From: Bloomer, David <David.Bloomer@lancashire.gov.uk>
Sent: 30 May 2018 09:07
To: Adrian Dowd
Cc: LHS Customer Service; planning
Subject: app3/2018/0395 Susie Cottage Rimmington Lane

In the previous comments to app 17/1021 concern was raised about the parking provision and in the absence of a parking layout accommodating a minimum of 3 vehicles the recommendation was for a refusal. The submitted plan shows 3 parking spaces and on this basis I would raise no objection to the proposal on highway grounds. Should your council be minded to approve this application I would be grateful if you could attach the following Conditions / notes

Proposed Site

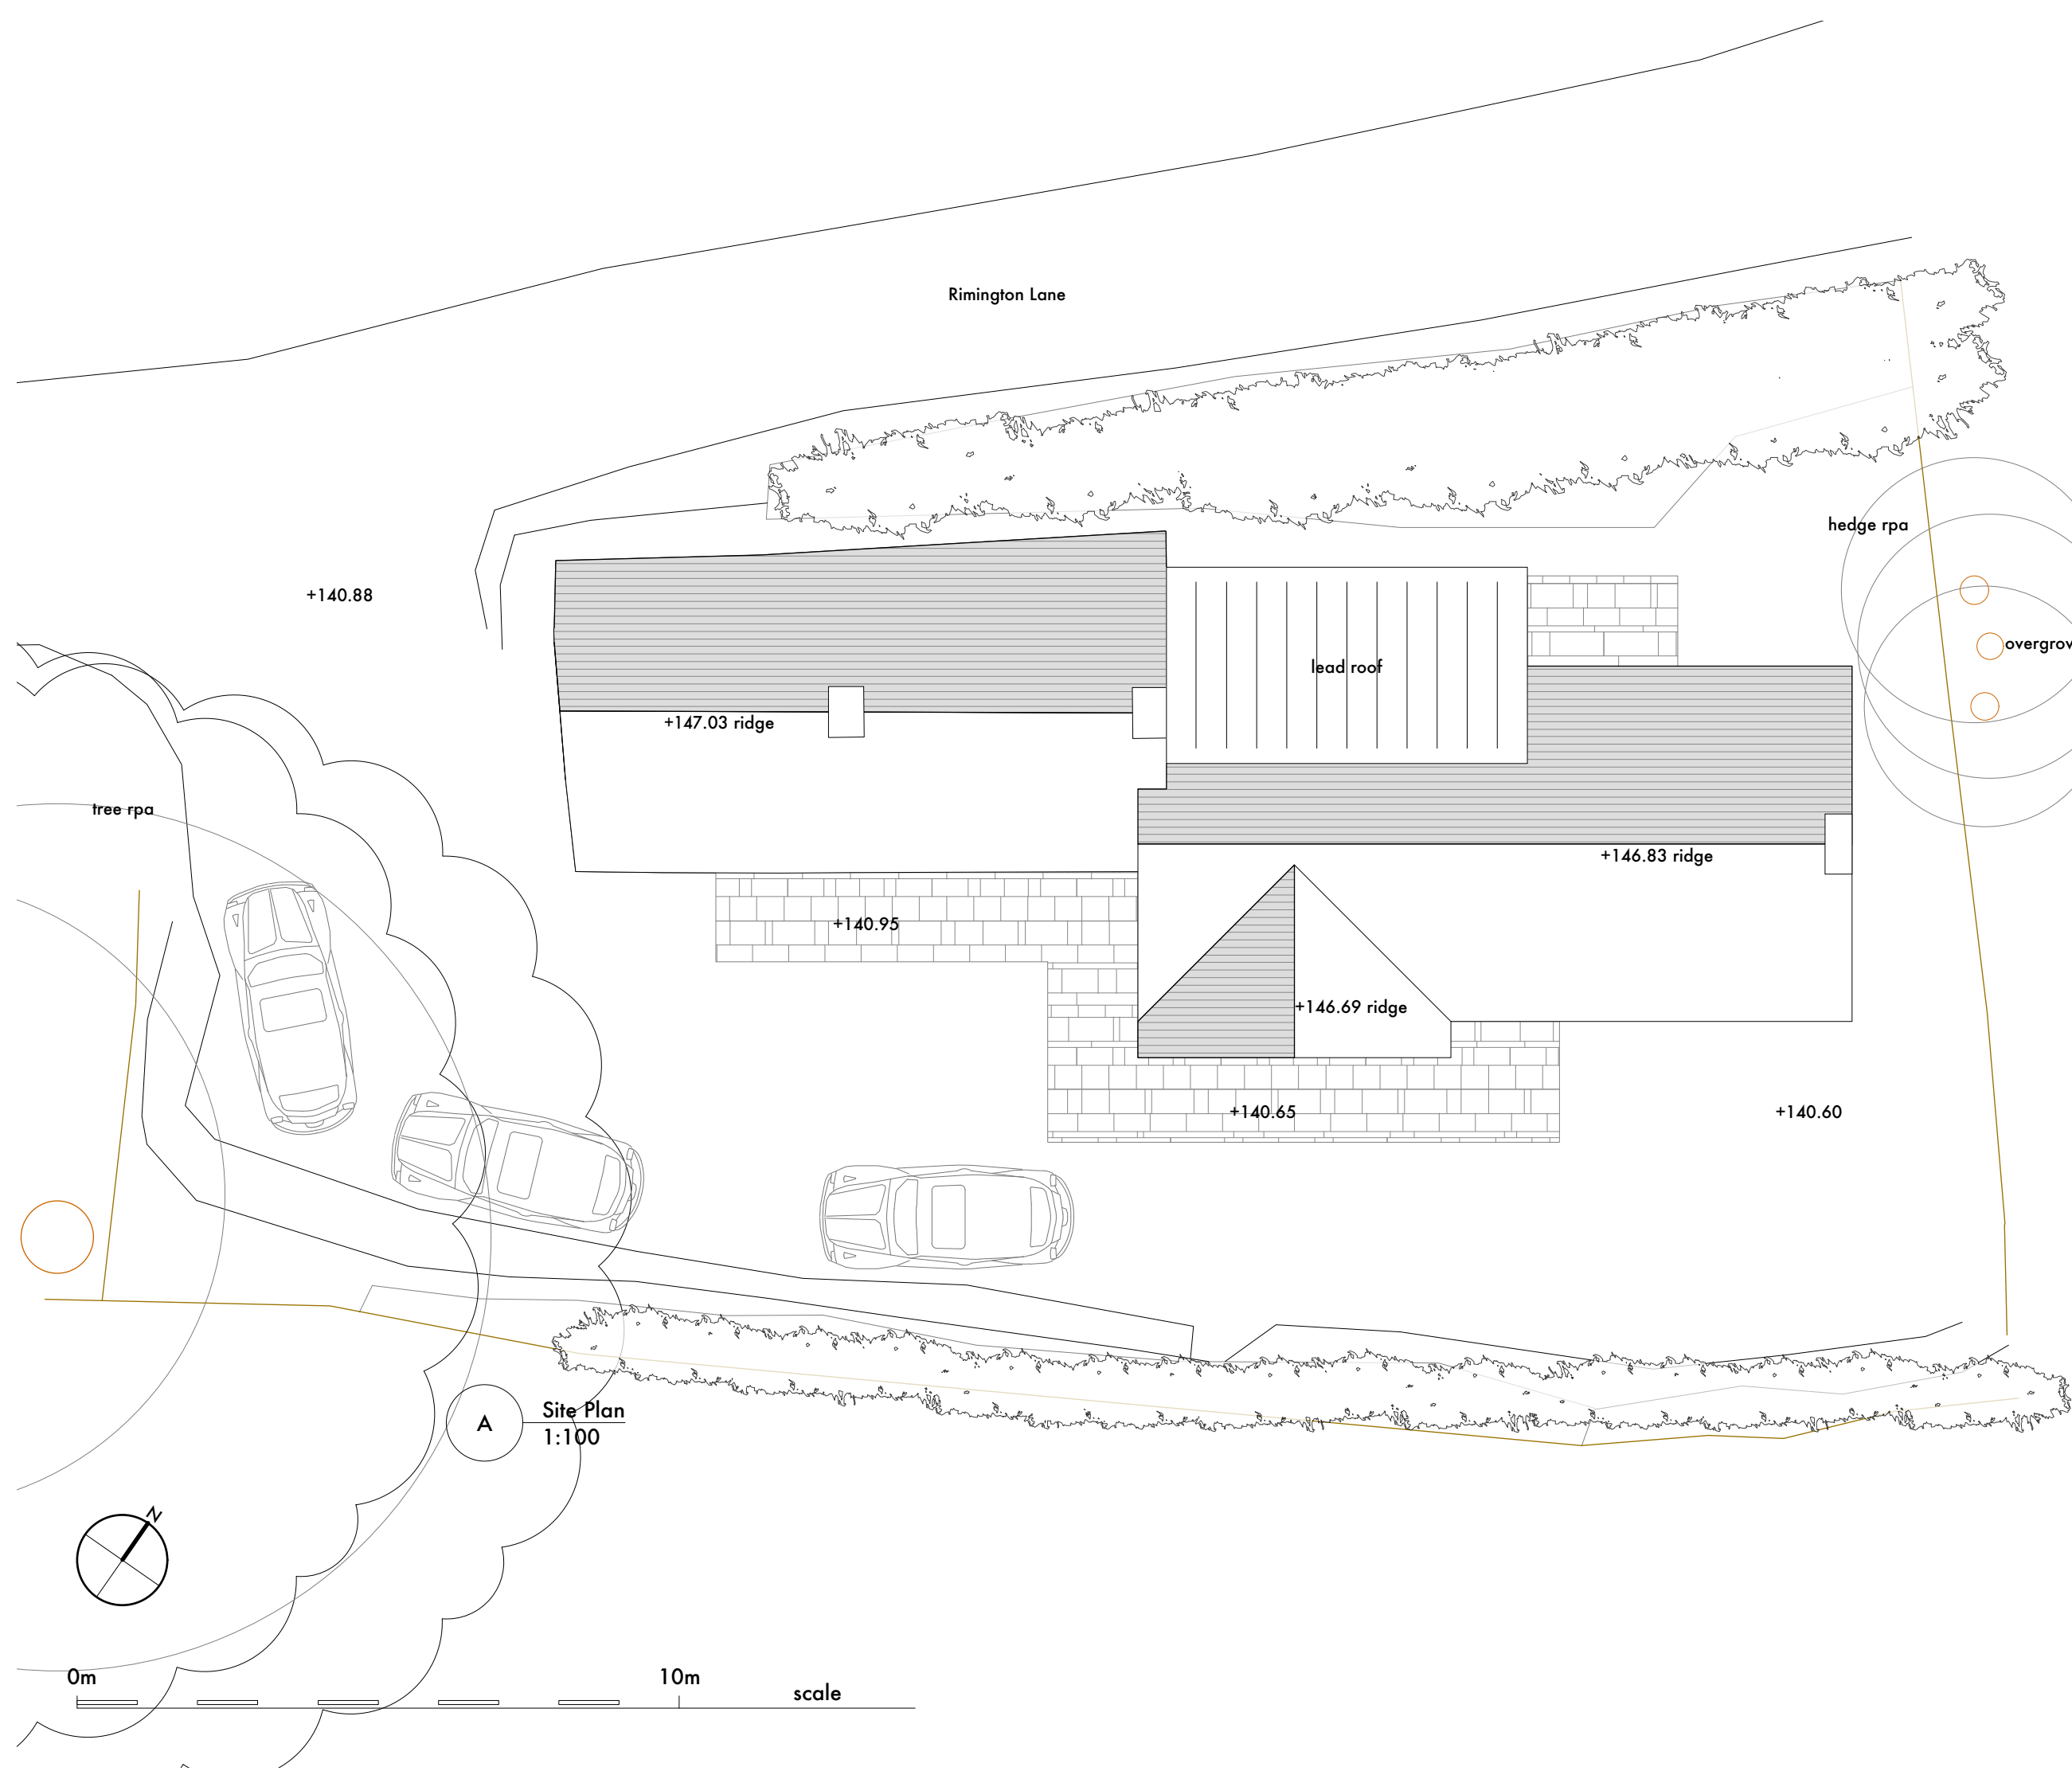
1. Before the development hereby permitted becomes operative, the existing hedge and vegetation on the highway frontage of the site to Rimington Lane shall be reduced to and be permanently maintained henceforth at a height not greater than 1m above the crown level of the carriageway of Rimington Lane. Reason: To ensure adequate visibility for the drivers of vehicles entering and leaving the site.

4. Any hard standing for vehicle parking should be appropriately paved in tarmacadam, concrete, block pavements, or other approved materials for a distance of 5m back from the edge of the carriageway Reason: To prevent loose surface material from being carried on to the public highway thus causing a potential source of danger to other road users.
